Y/72/20/RES

Land at Stakers Farm North End Road Yapton

Approval of reserved matters following outline approval Y/44/17/OUT for the erection of 70 No. dwellings, public open space, play area, drainage & landscaping. This application affects the character & appearance of the Main Road/Church Road Yapton Conservation Area & affects the setting of Listed Buildings.

REV	DESCRIPTION	DATE	AUTHOR	CHECKD
CLIENT				
dandara new homes				
PROJECT				
LAND AT NORTH END ROAD YAPTON				
DRAWING				
BOUNDARY TREATMENT LAYOUT 70 UNIT SCHEME				
SCALE 1:500 @ A1		DATE 02.08.19	AUTHOR LAH	CHECKED -
JOB NO 102-70		DRAWING NO PL-07	REV -	REV -
BRIMSTONE DESIGN LTD

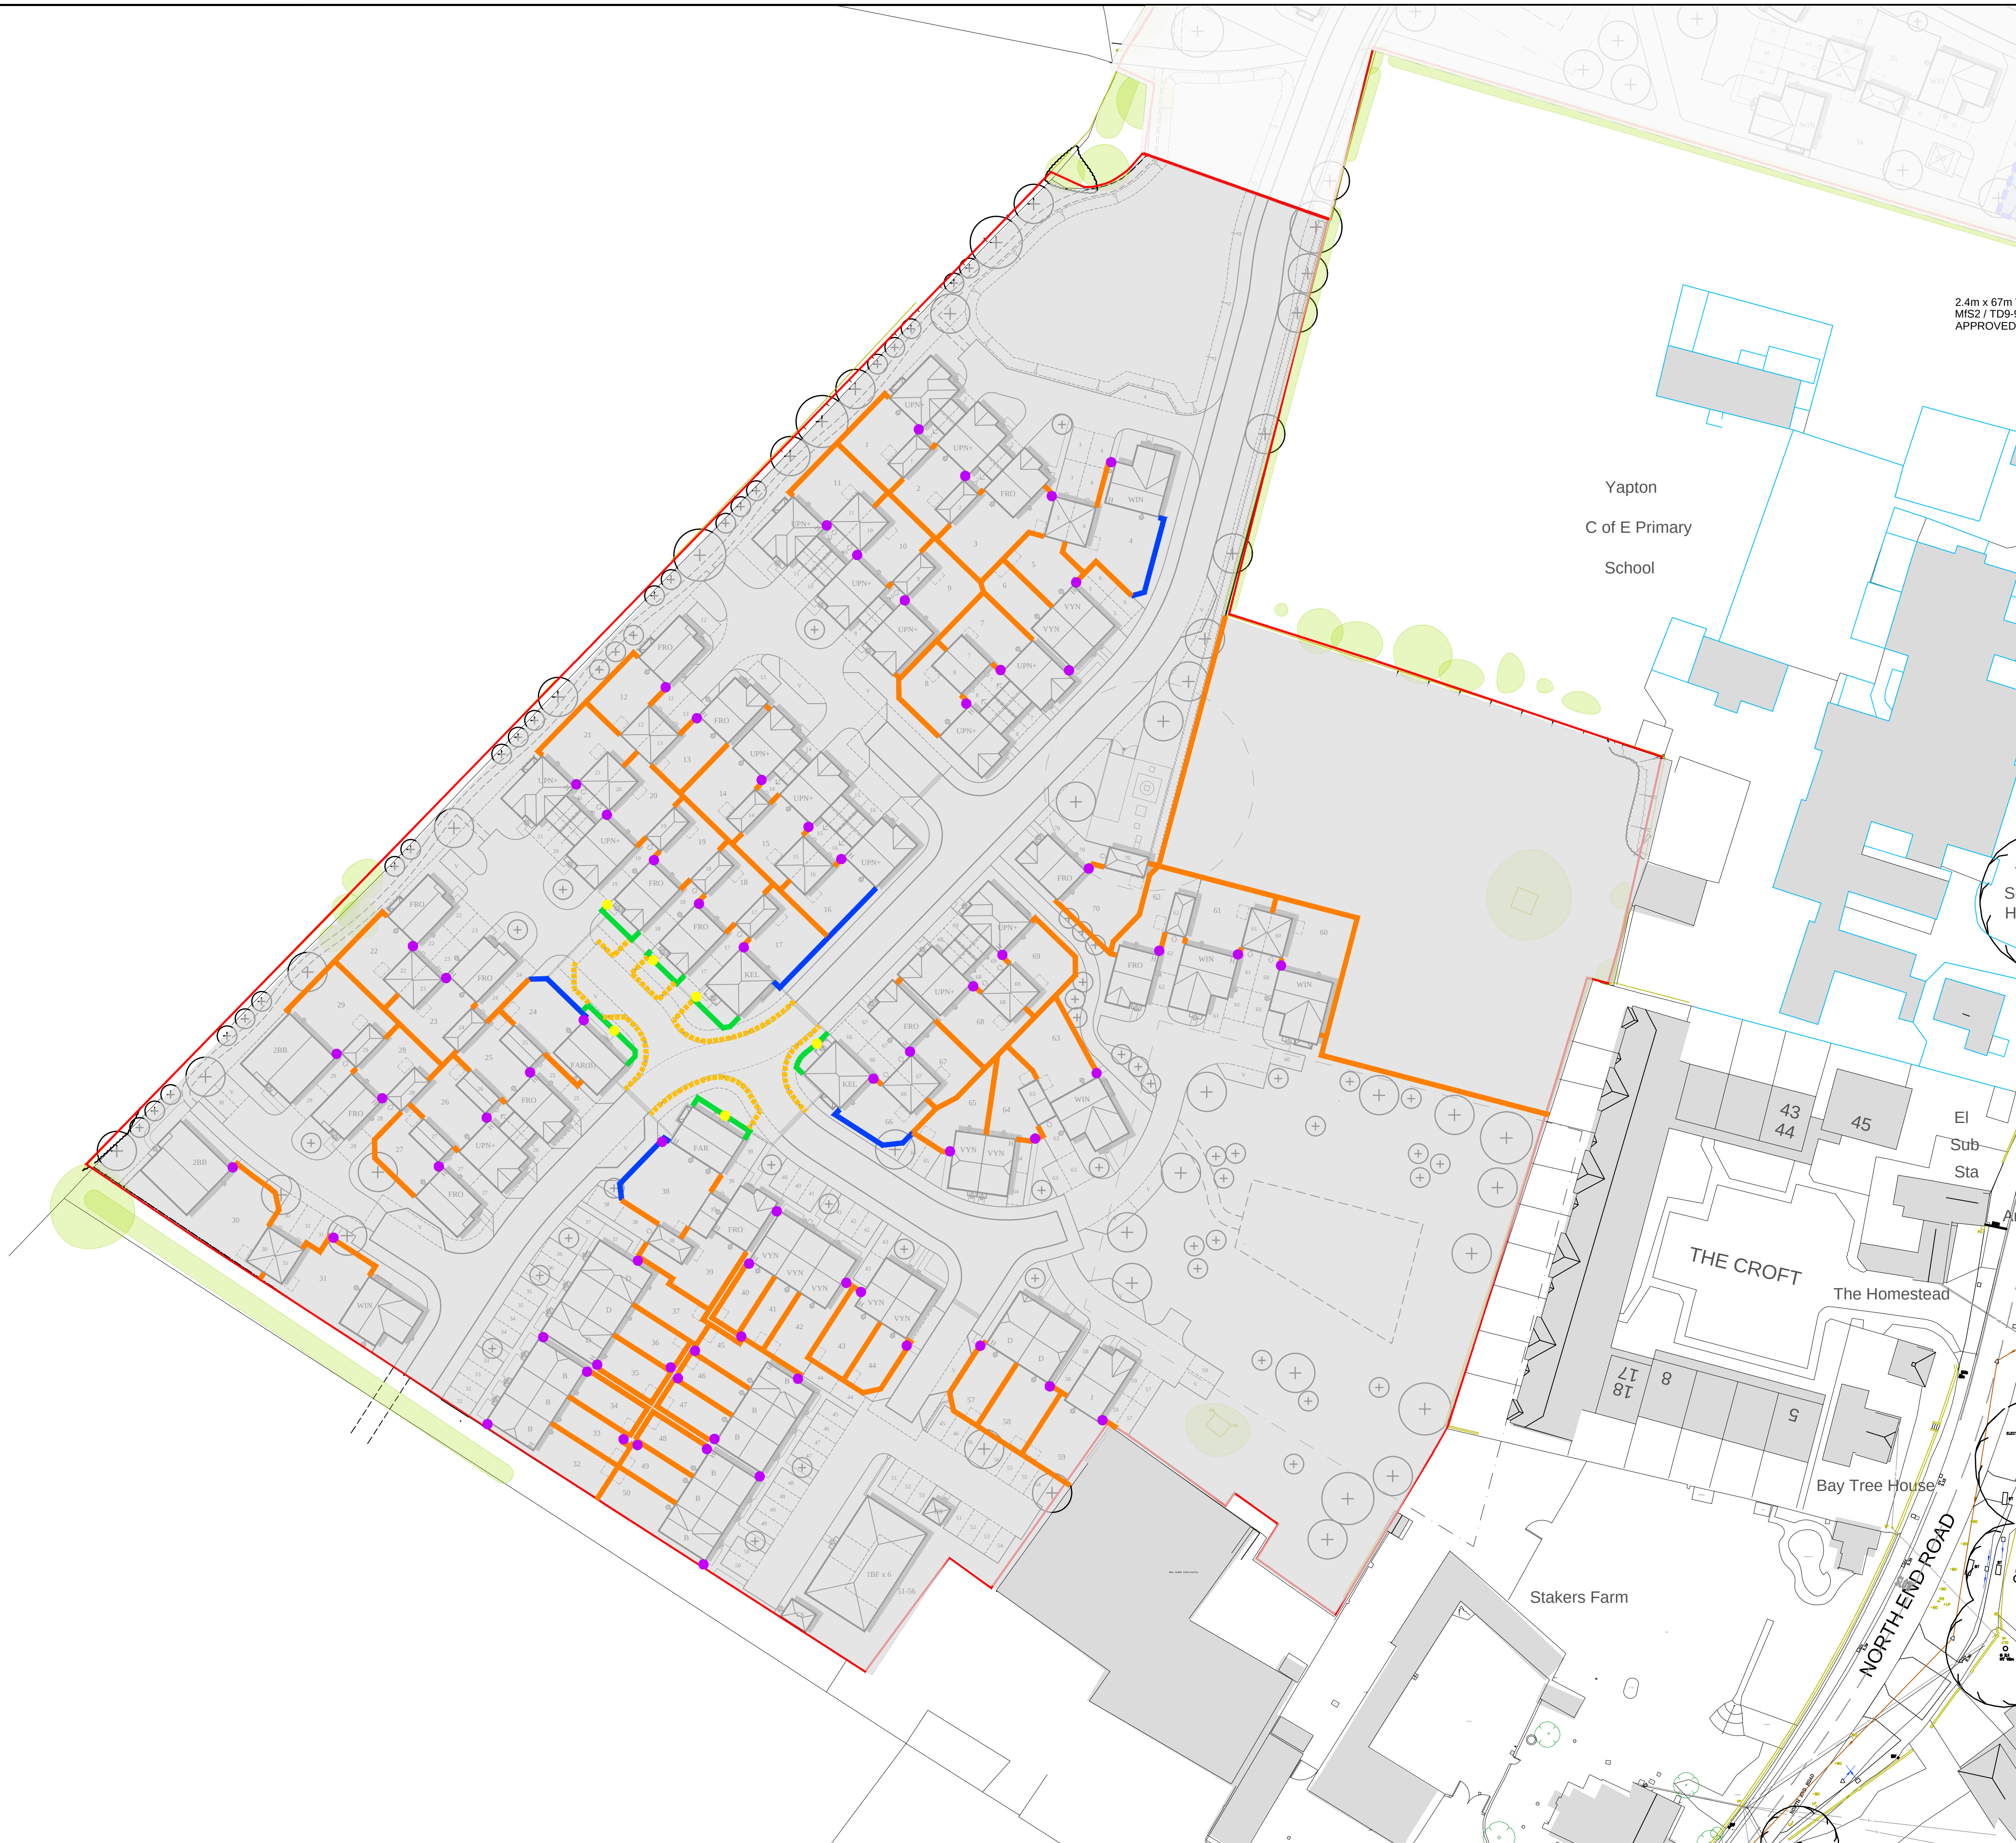
Also, of note is a potential issue regarding the landscaping and part of the boundary with the neighbouring listed building (Stakers Farm and barns). It is believed that a stretch of the shared boundary is open and that as a result, some form of walling will be required in order to divide the two sites. As it could be considered to form the curtilage of the listed building, it is assumed that permission would be required from the LPA. Details of the means of enclosure should be provided, ideally in the form of a wall to match the existing.

**PLANNING LAYOUT  
70 UNIT SCHEME**

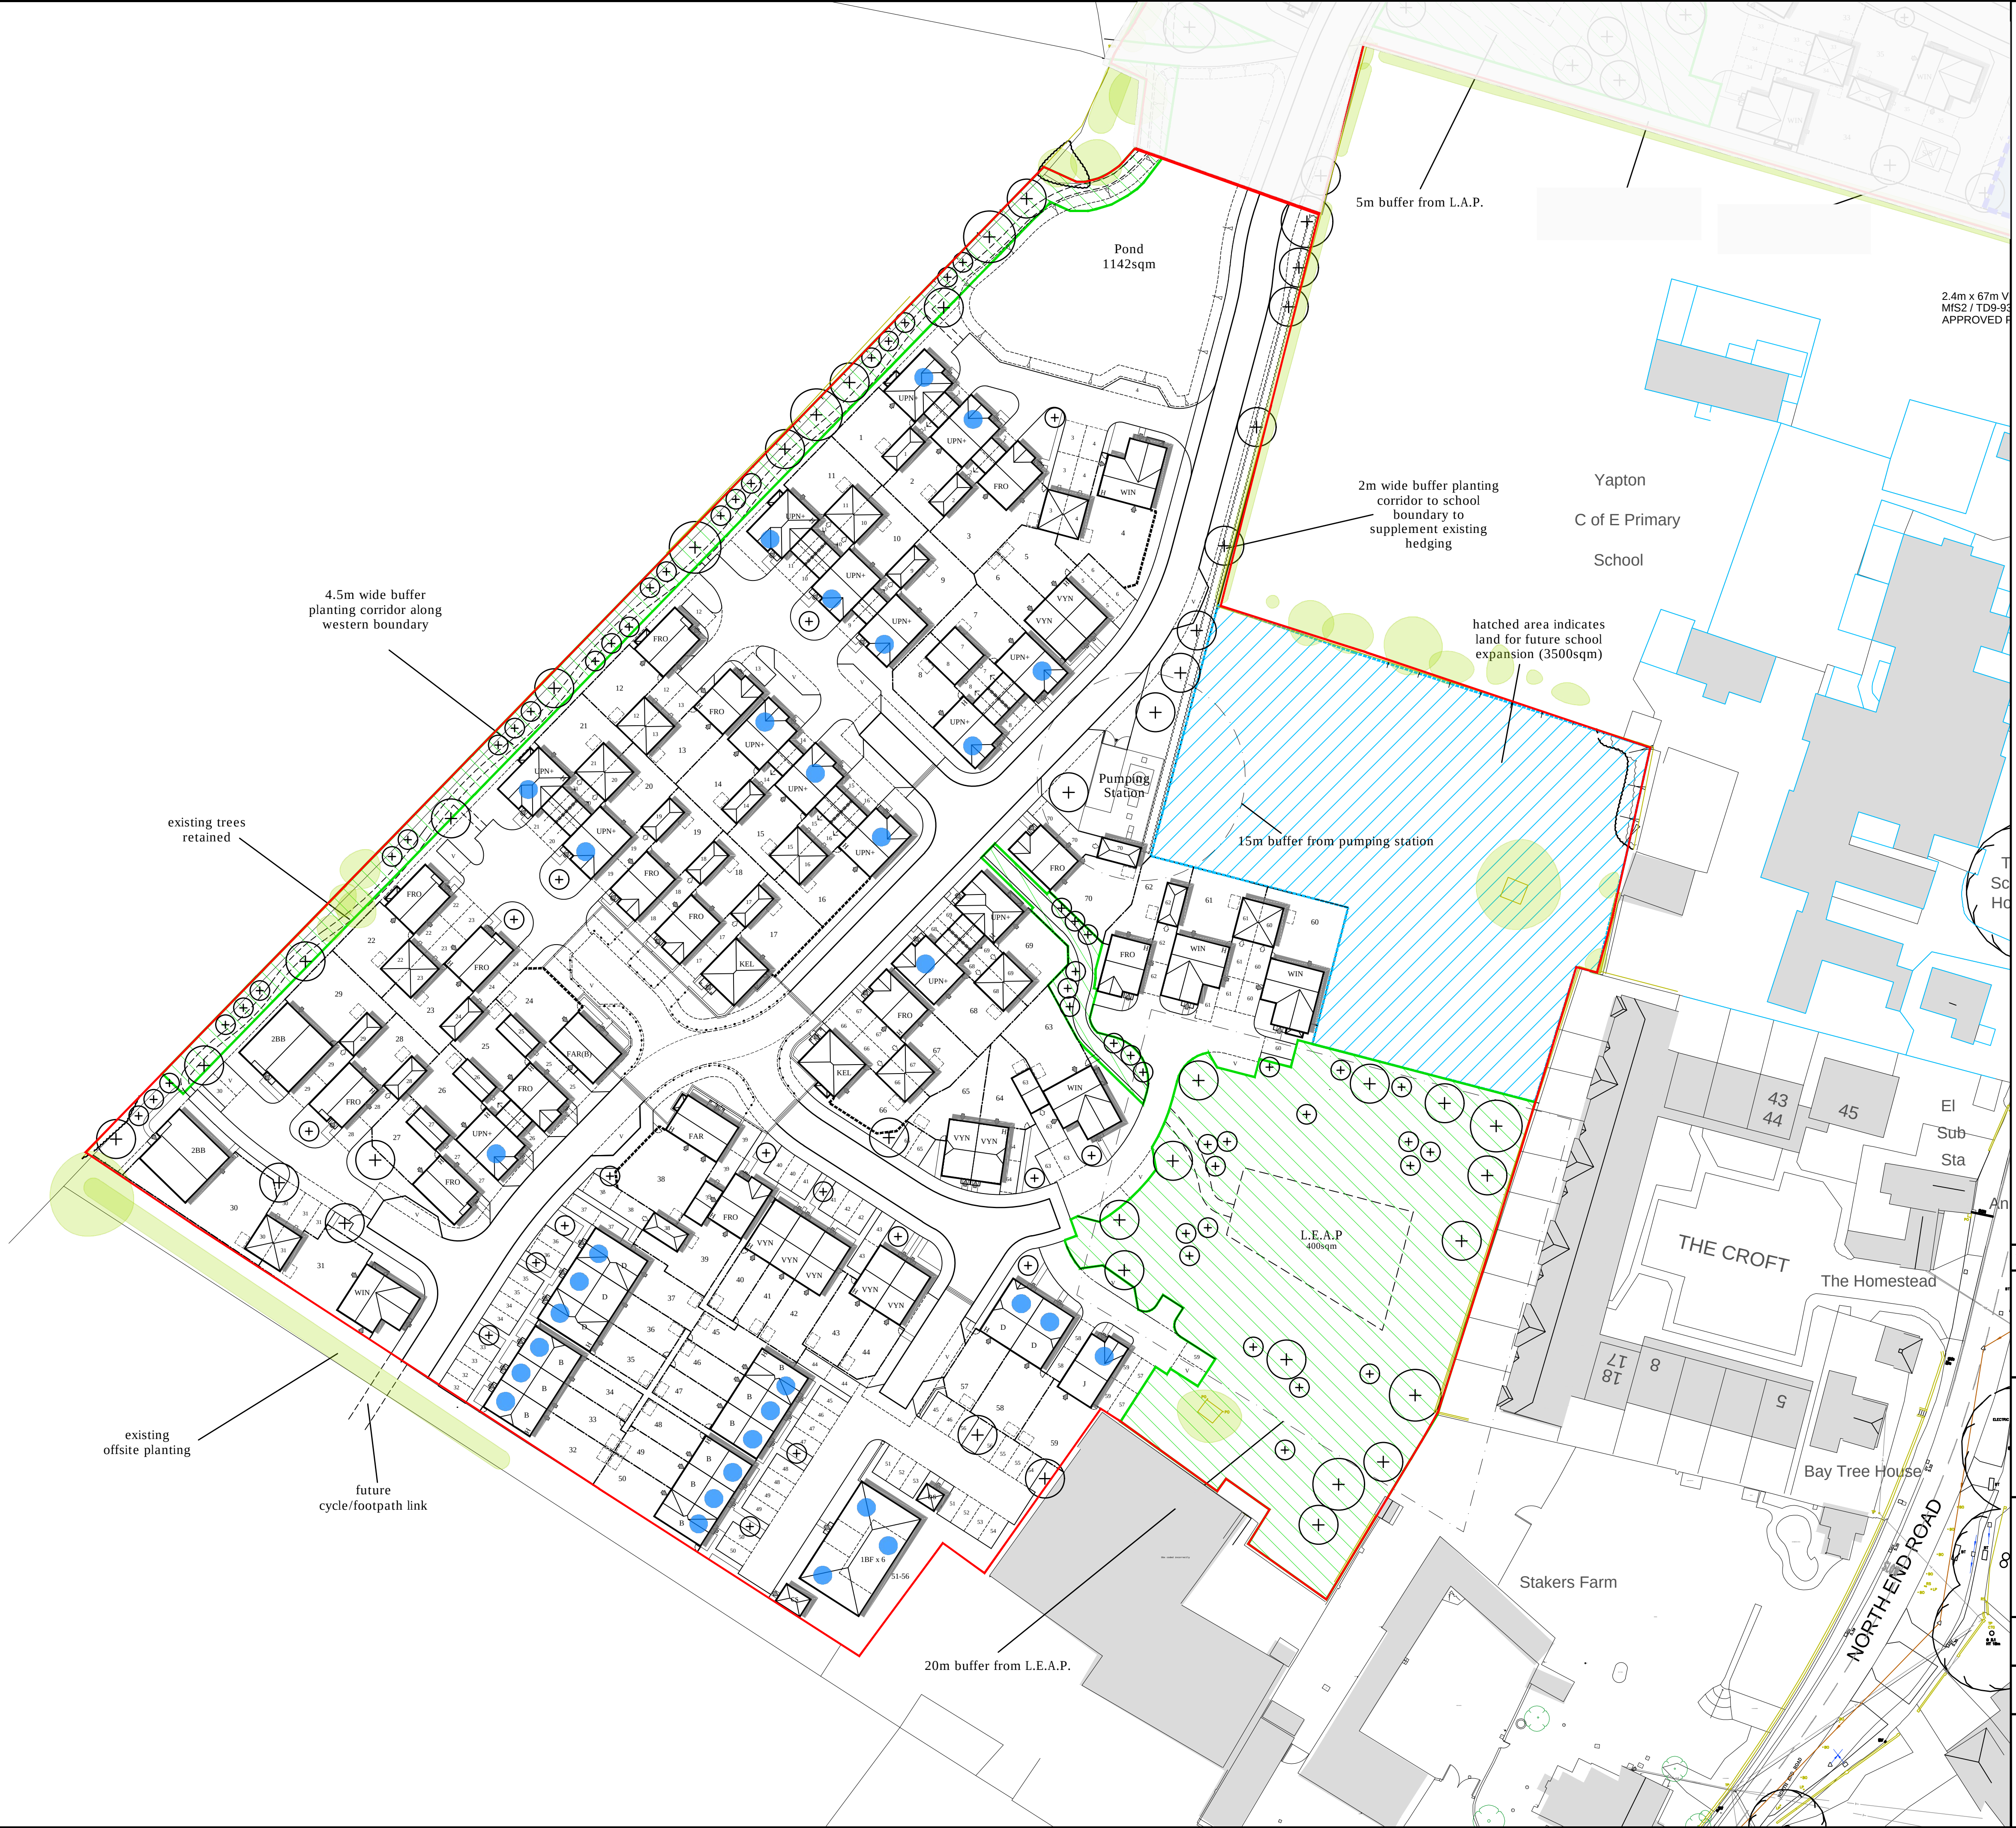
The proposed development consists of 70 dwellings along with the associated infrastructure, including open space. The open space is located in the south eastern part of the site which provides some separation between both Stakers Farm (and curtilage listed barns) and the conservation area and the development. Landscaping would help to screen the development, whilst providing some visual separation between it and the conservation area. Any landscaping should be of an appropriate scale in order to ensure that the impact is reduced as the development is completed.
